12 Jerome Way, Shipton On Cherwell, Kidlington,
OX5 1JT

23/00777/F

Proposal: Single storey side extension, front porch extension, part two storey and part single storey rear extension together with associated internal and fenestration alterations

Drawing Title
 PROPOSED GROUND
 FLOOR PLAN

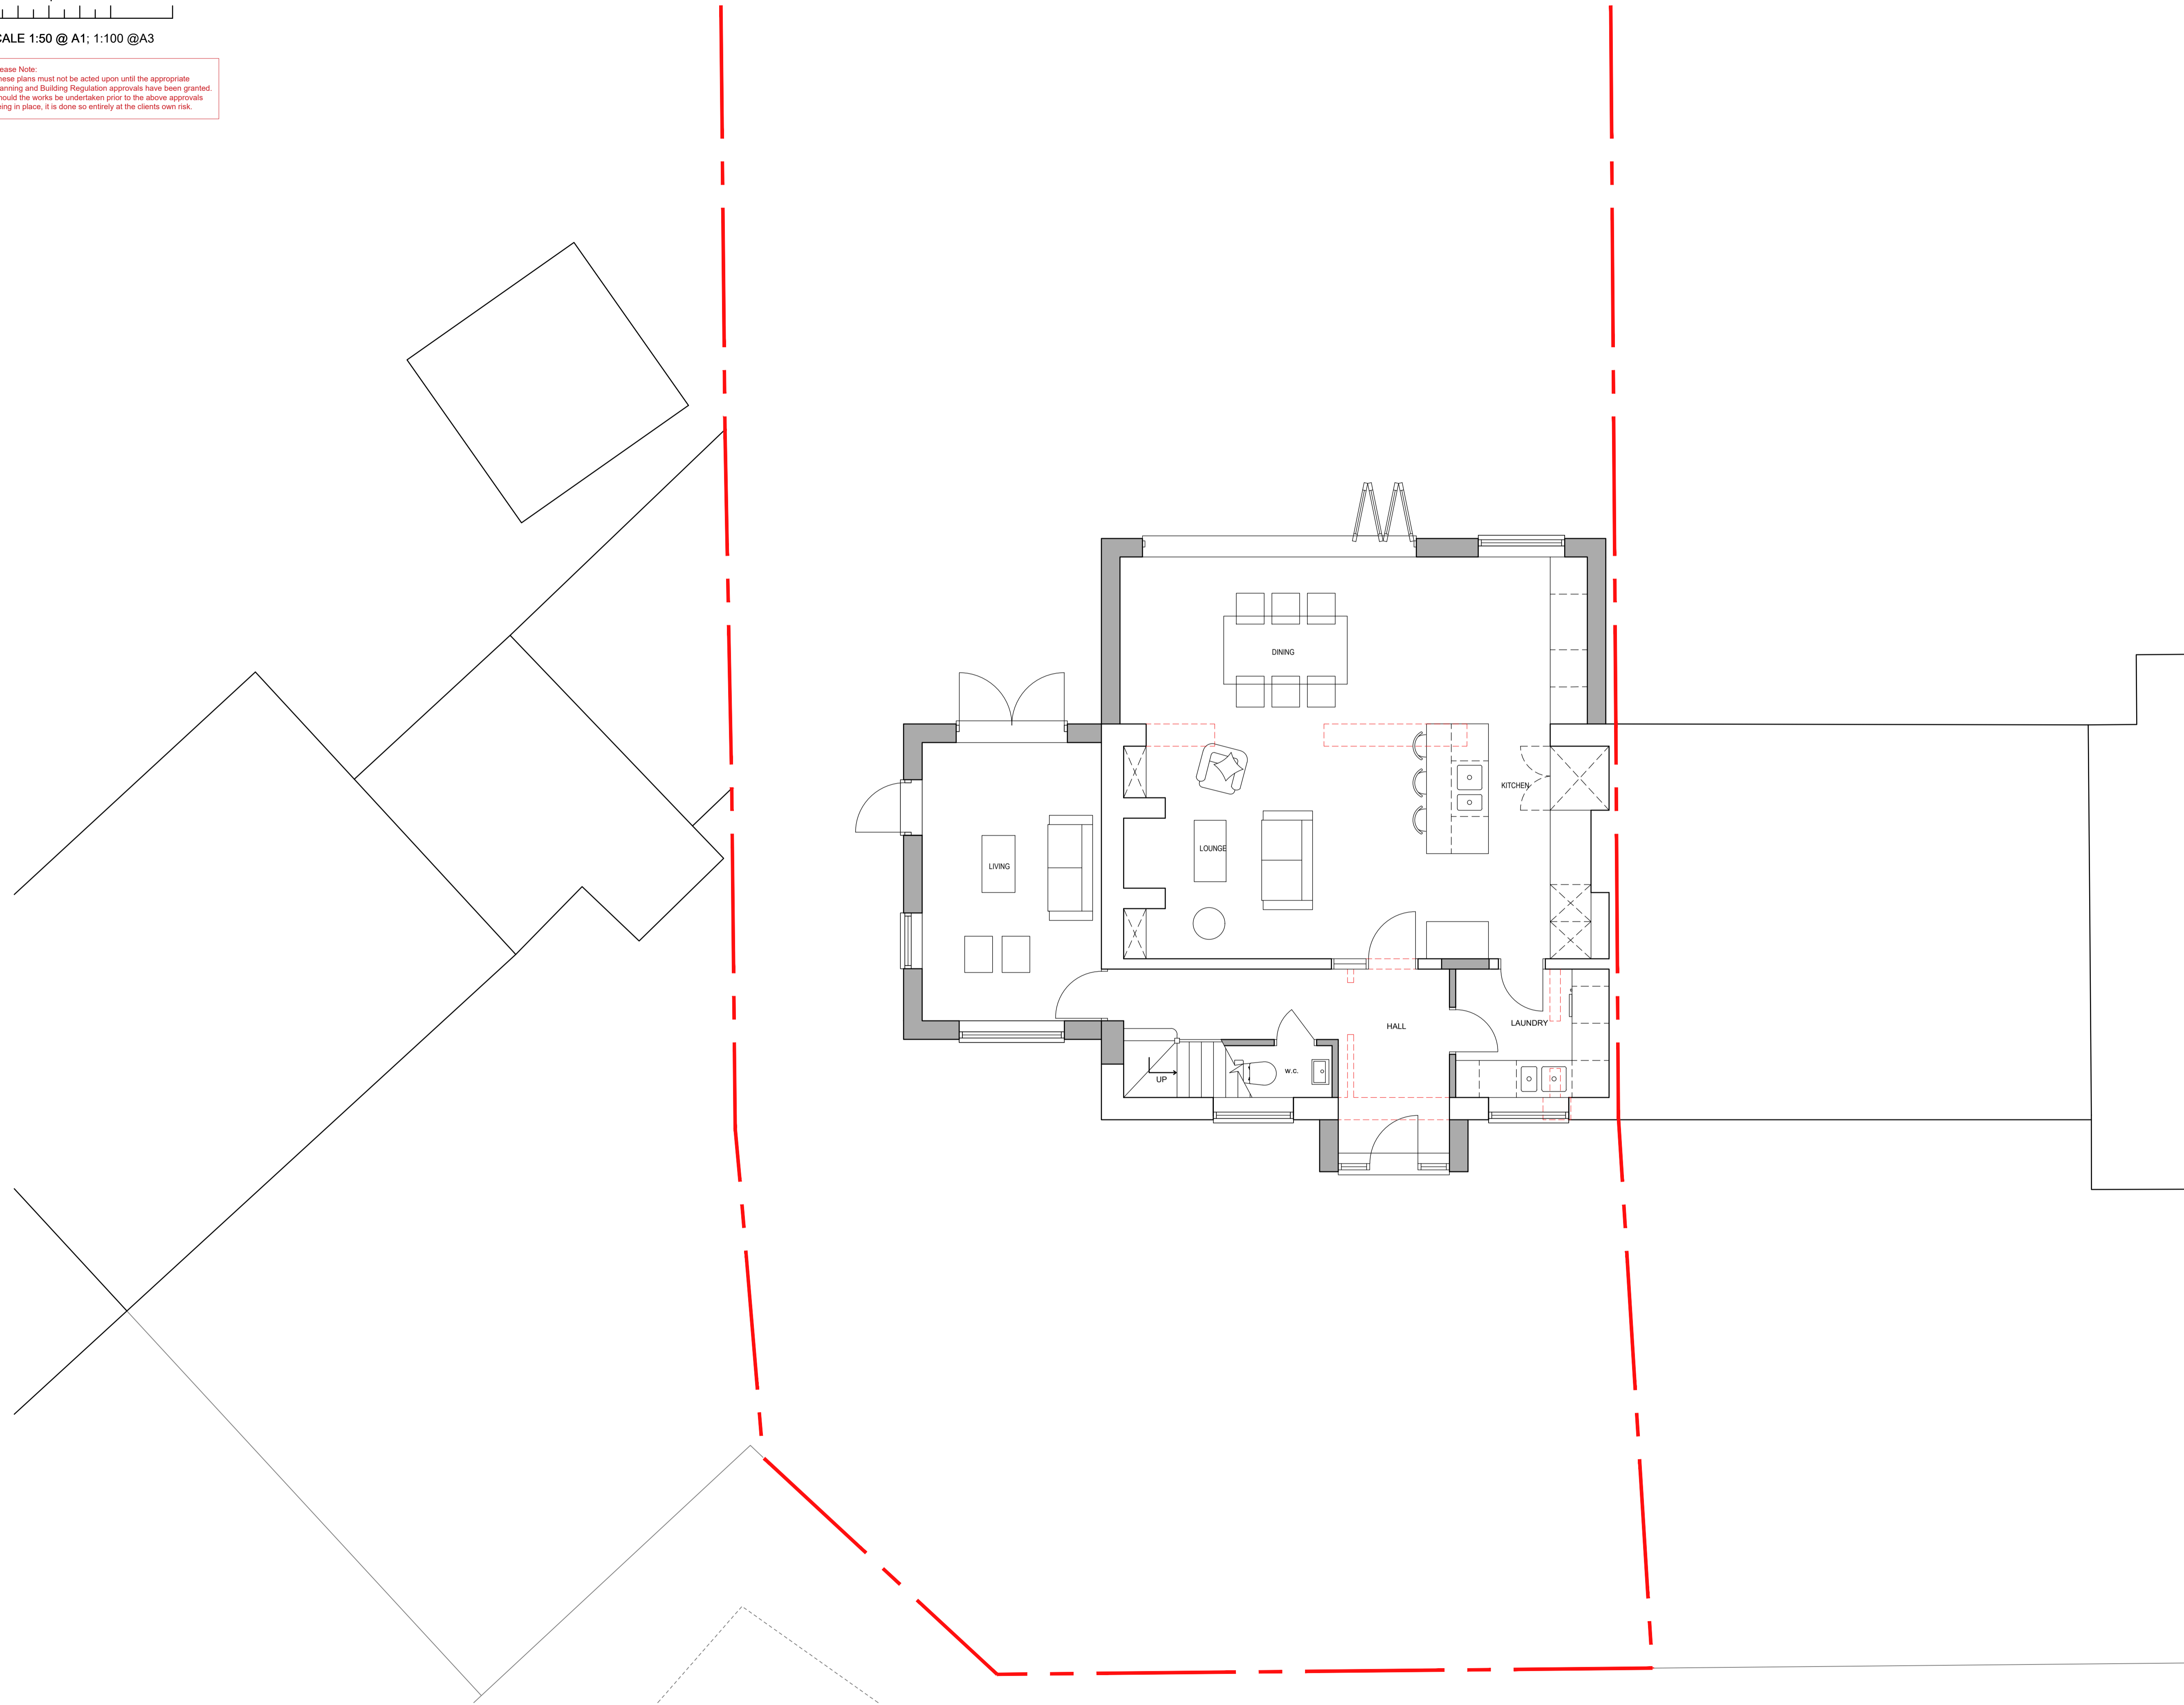
The proposed front porch extension would be approx. 2m² with a gable roof where the ridge height would be close to the first-floor windows. Guidance is set out within chapter 5 of the Home Extensions & Alterations Design Guide March 2007 which advises that front extensions should normally be limited to appropriately sized porches and that porches should reflect the character, proportion, and scale of the existing building. Front porches in the area are characterised by a variation of different styles normally modestly sized. The porch size has been reduced from the original application. Although the comments of the Parish Council are noted, the revised porch design is a proportionate size and is considered to be of an acceptable design.

The proposed front porch would be set well off the boundaries of the adjacent neighbours to not cause any significant impact on these residents.
